Re: QuikTrip 7001, Albuquerque
Matkin Hoover Job No. 7001.01

TCL No. K10D070

This letter and its attachments serve as a response to comments received on May 16th, 2024, concerning the above referenced project.

SHEET NUMBER:
C510
17 OF 25

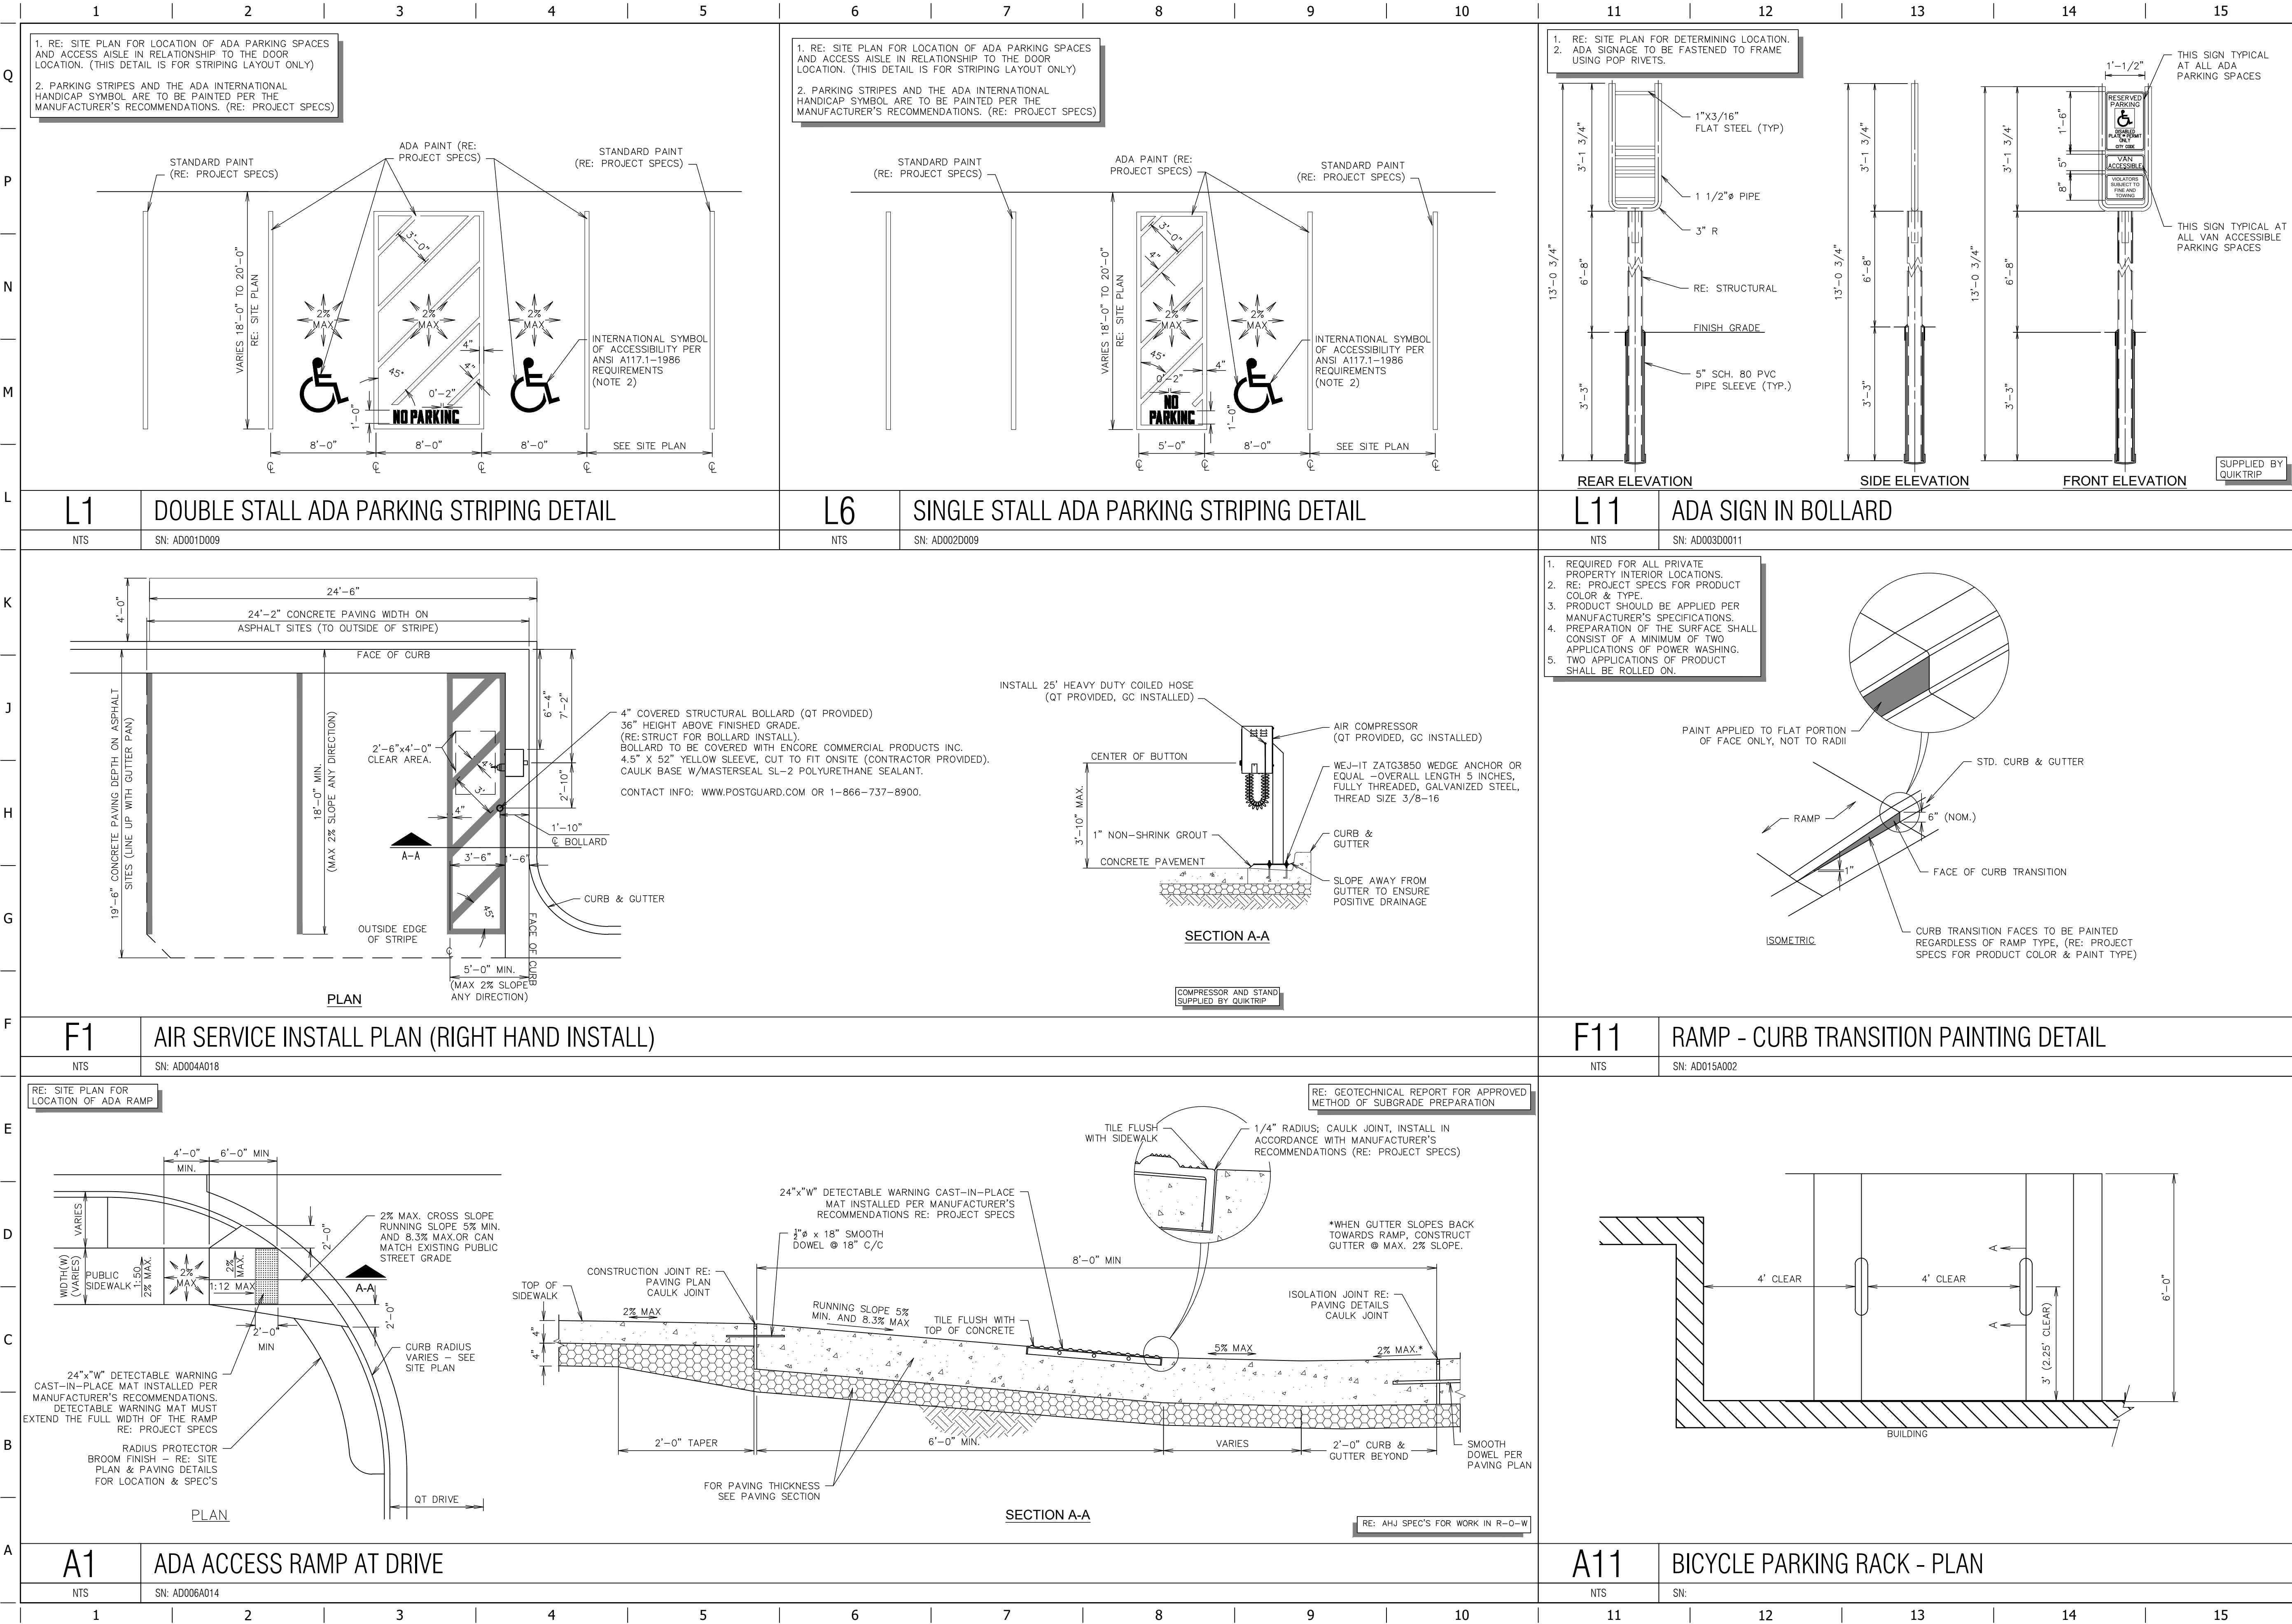
The ADA accessible parking sign must have the required language per 66-7-352.4C NMSA 1978 "**Violators Are Subject to a Fine and/or Towing.**" Please call out detail and location of signs.

A 1-foot clear zone around the bicycle parking stall shall be provided.

Bicycle parking spaces shall be at least 6 feet long and 2 feet wide.

ADA Sign Stating “Violations Are Subject to a Fine and/or Towing” sign added to ADA Access Plan. Detail of sign has been included on Sheet C510, Detail L11.

Concur. Please refer to Sheet C510, Detail A11 and Sheet C510, Detail A1 for bike rack layout details highlighting the clear zones and space measurements.

Concur. Please refer to Sheet C510, Detail A11 and Sheet C510, Detail A1 for bike rack layout details highlighting the clear zones and space measurements.

SHEET NUMBER:
C511
18 OF 25

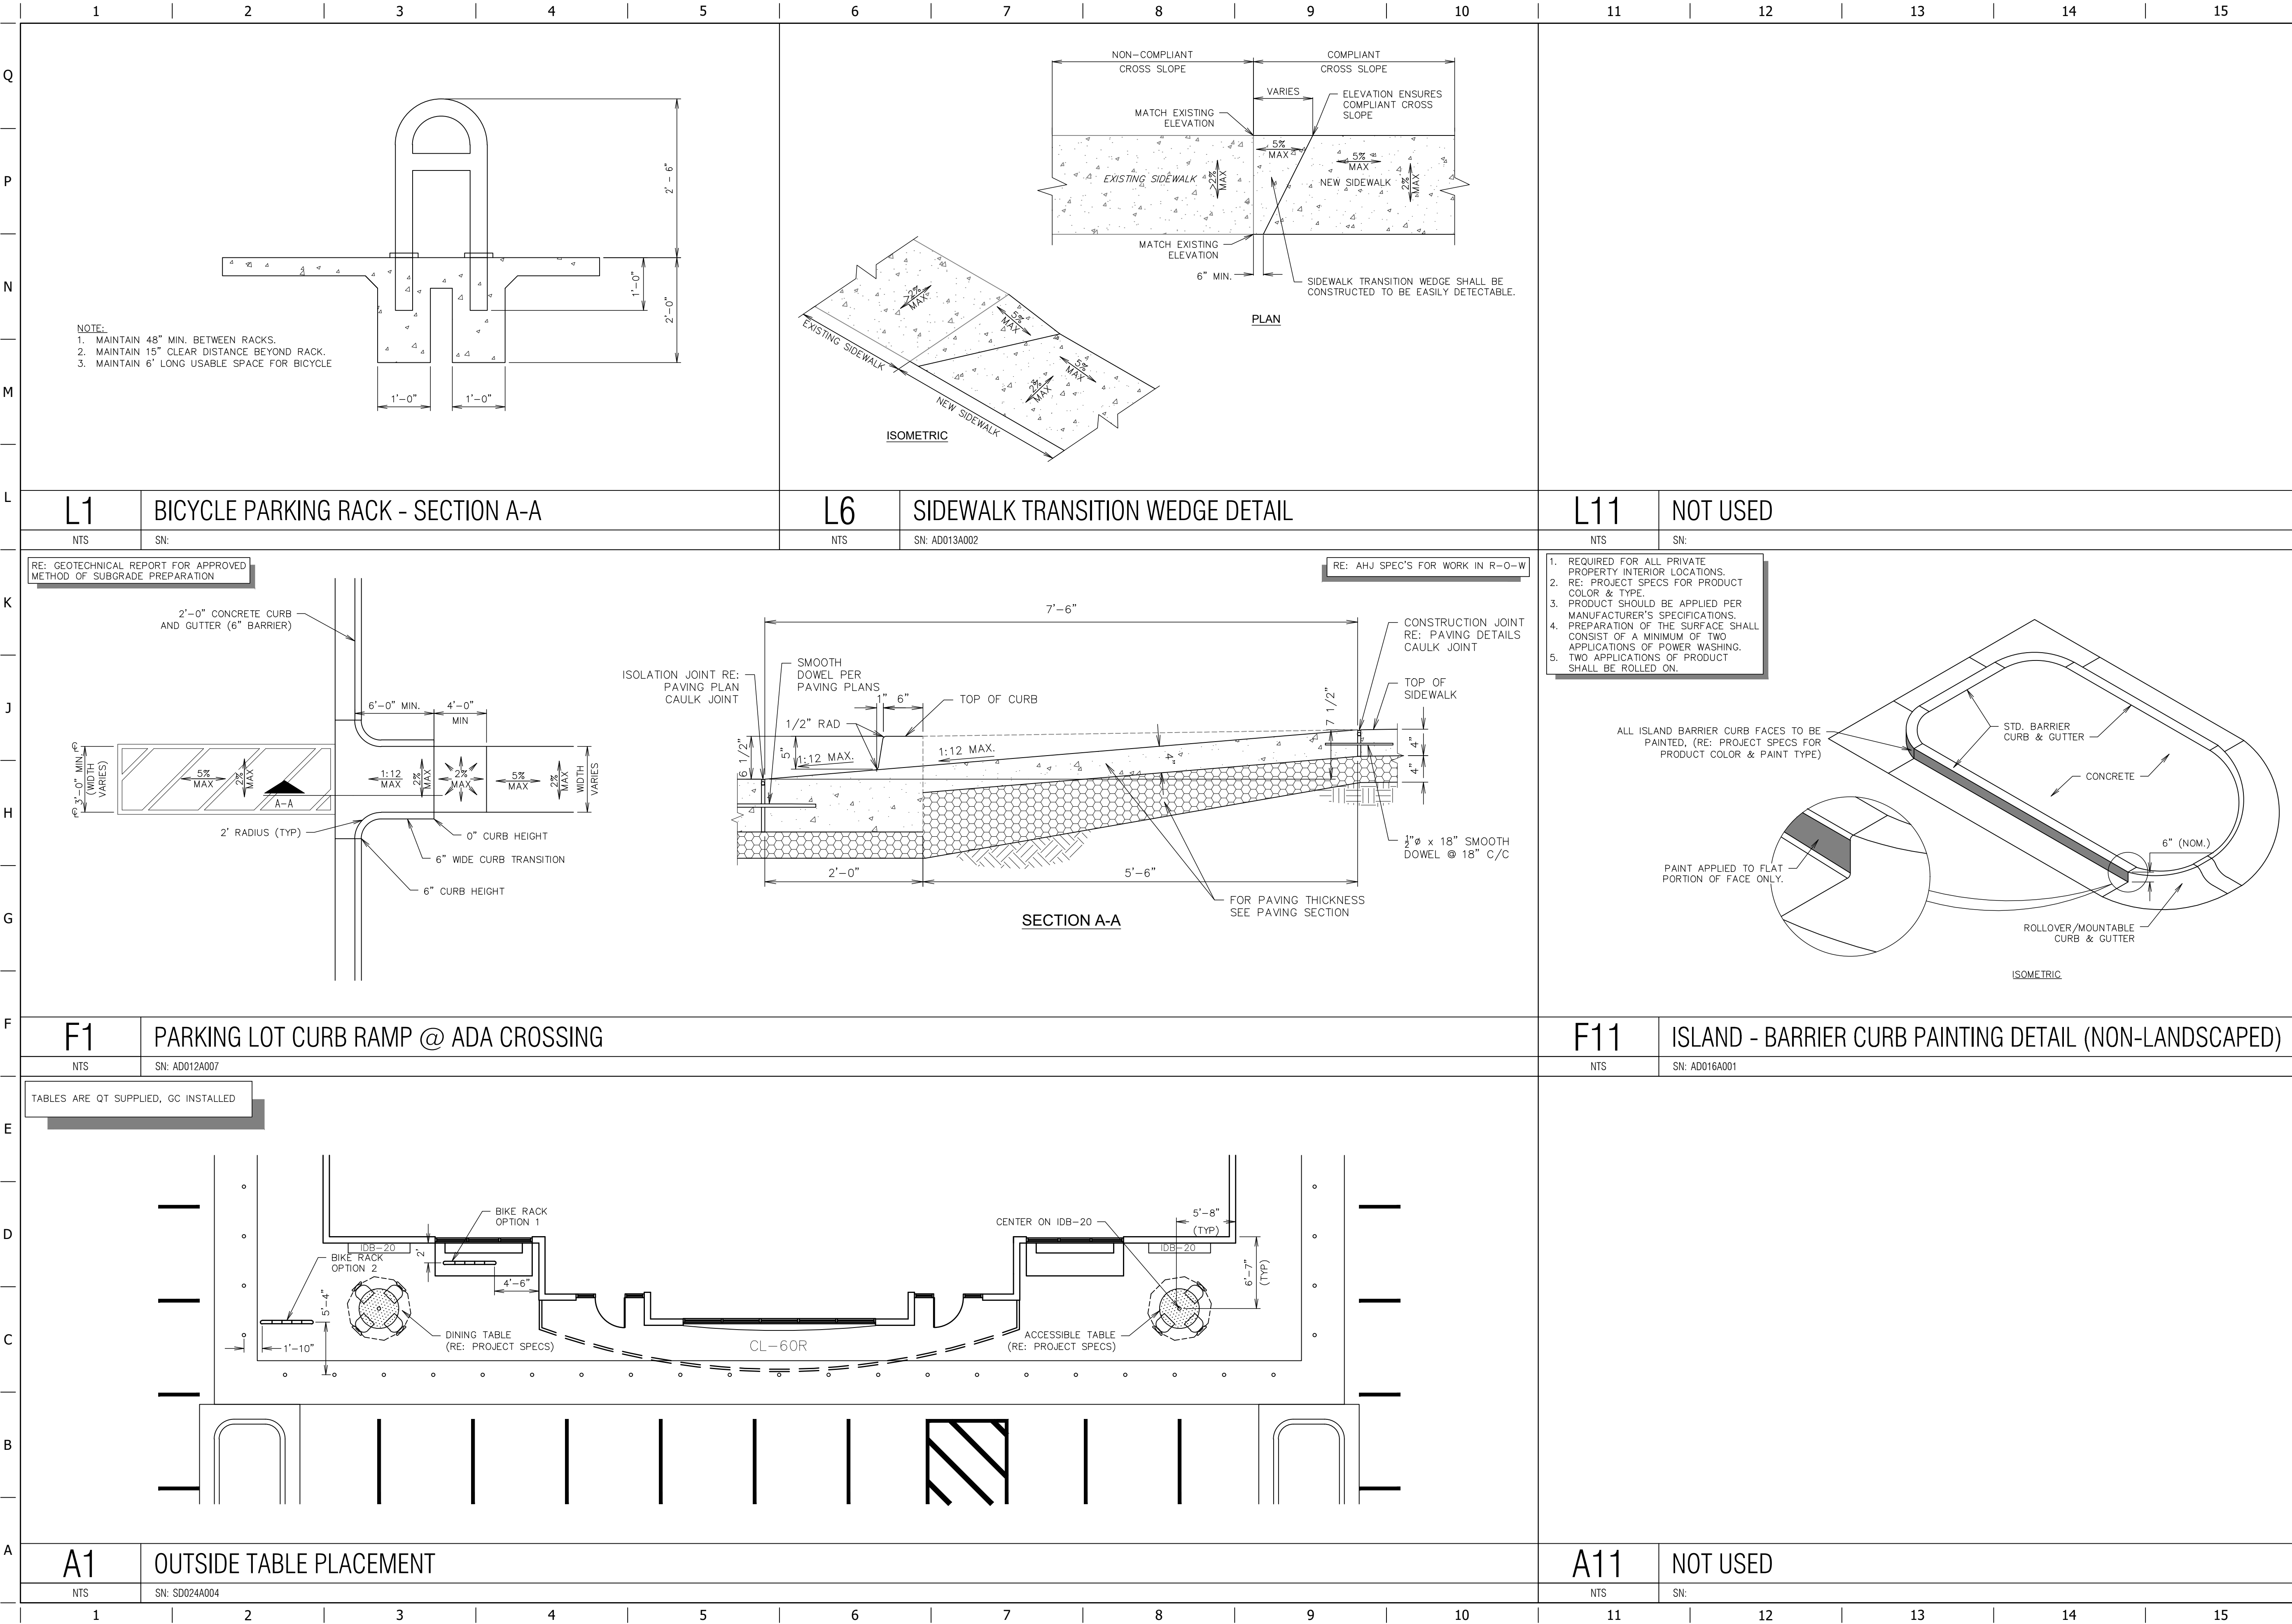
Concur. The ADA access aisles shall have the words "**NO PARKING**" in capital letters, each of which shall be at least one foot high and at least two inches wide, placed at the rear of the parking space so as to be close to where an adjacent vehicle's rear tire would be placed. (66-1-4.1. B NMSA 1978)

- All bicycle racks shall be designed according to the following guidelines:
- The rack shall be a minimum of 30 inches tall and 18 inches wide.
 - The bicycle frame shall be supported horizontally at two or more places.
Comb/toaster racks are not allowed.
 - The rack shall be designed to support the bicycle in an upright position. See the IDO for additional information.
 - The rack allows varying bicycle frame sizes and styles to be attached.
 - The user is not required to lift the bicycle onto the bicycle rack.
 - Each bicycle parking space is accessible without moving another bicycle.

Bicycle racks shall be sturdy and anchored to a concrete pad.

Concur. “NO PARKING” added to ADA access aisles using double stall ADA Parking Striping Detail, found on sheet C511, Detail L11.

Concur. Bike rack has been revised to meet the above requirements. Details for said bike rack can be found on Sheet C511, detail L1.

Concur. Bike rack has been revised to meet the above requirements. Details for said bike rack can be found on Sheet C511, detail L1.
